**CITY OF FOUNTAIN ELECTRIC DEPARTMENT
REVIEW COMMENTS**

TO: KRISTY MARTINEZ
FROM: TRACY TILLMAN DISTRIBUTION SYSTEM DESIGNER
SUBJECT: A REQUEST FROM EL PASO COUNTY TO REVIEW THE COTTAGES AT MESA RIDGE FINAL PLAT (AKA MESA RIDGE SUBDIVISION FILING NO. 10).
DATE: 3-22-22
CC: DAN BLANKENSHIP; CARL CHRISTIAN; CODY CLARK; RANDAL BURROWS; GILBERT JAIME; GABY SERRANO; MELANIE ESTRADA

PROJECT No.: 20-035 SHEET 2 OF 3

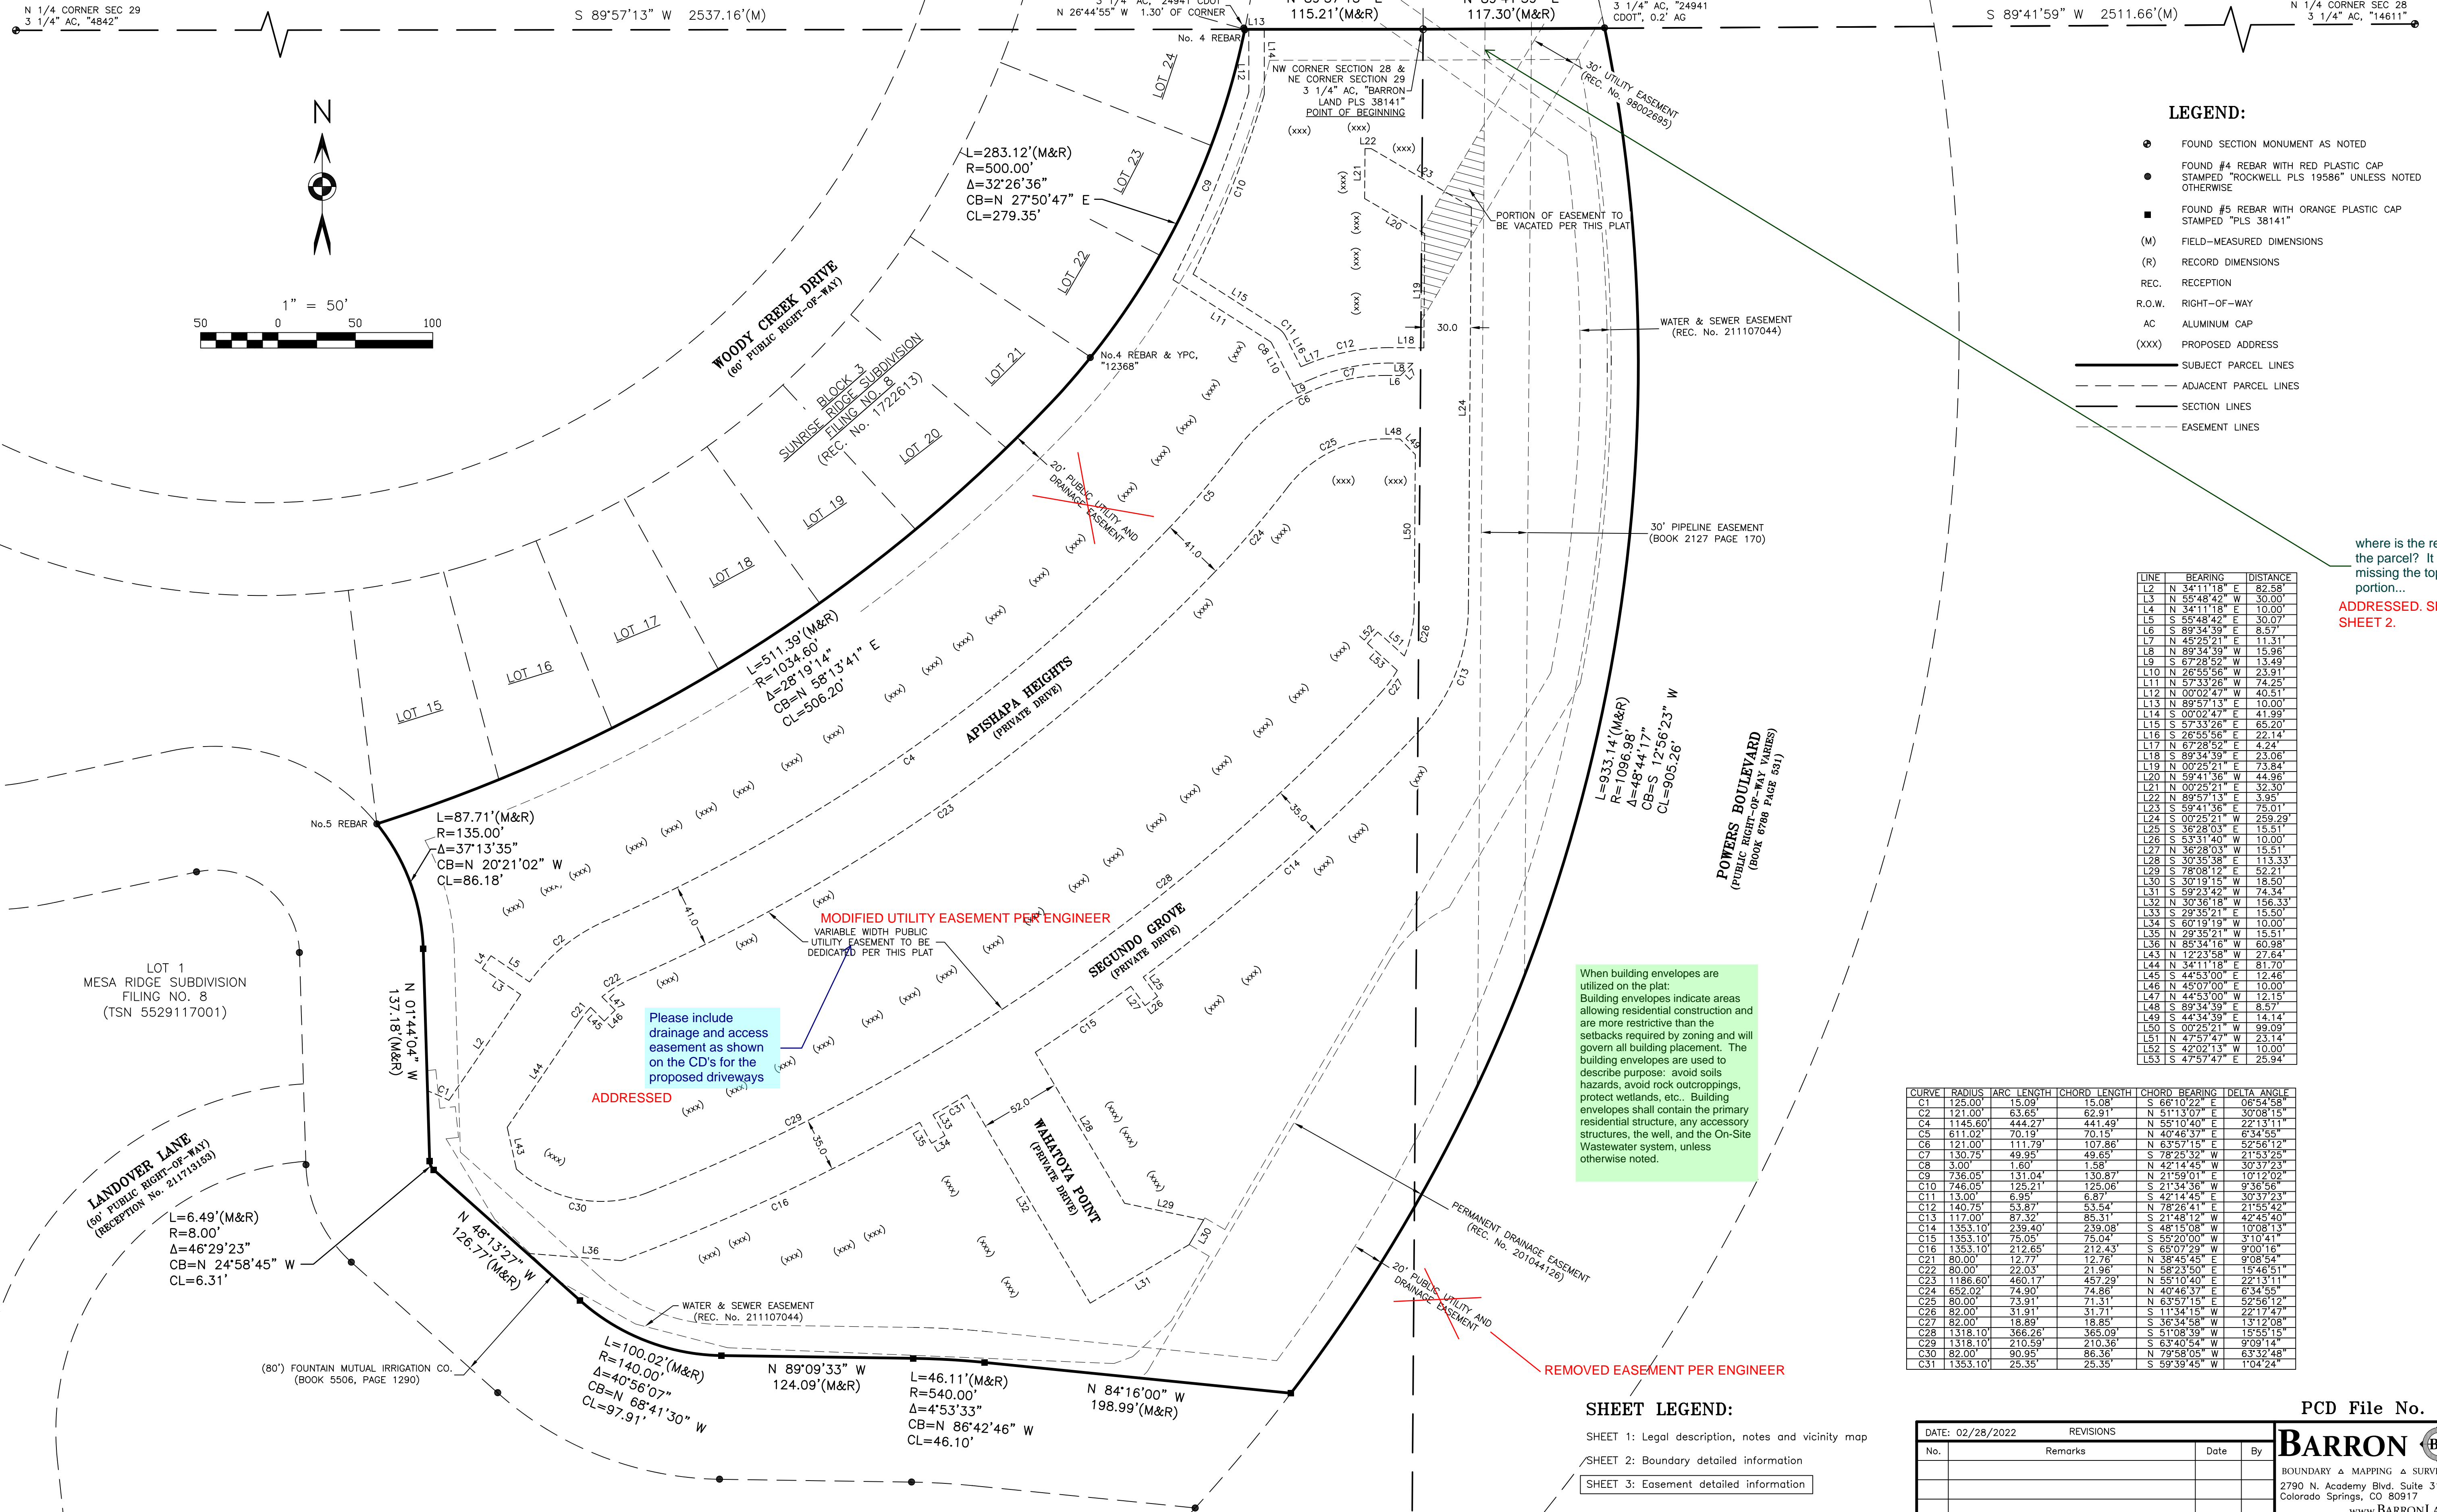
Please note that the developer will be required to provide all on site and off site easements to serve this development, to include easements that will provide a redundant loop feed to ensure reliable service for the entire project. The developer will also be responsible for and costs associated with all on site and off-site improvements including line extensions and street lighting, etc.

Additional easement required

Yellow line is the location of proposed primary power source please add 10ft easement to site plan

Response: Plat updated with easments based on preliminary electrical design provided by COF Electrical Dept. (attached)
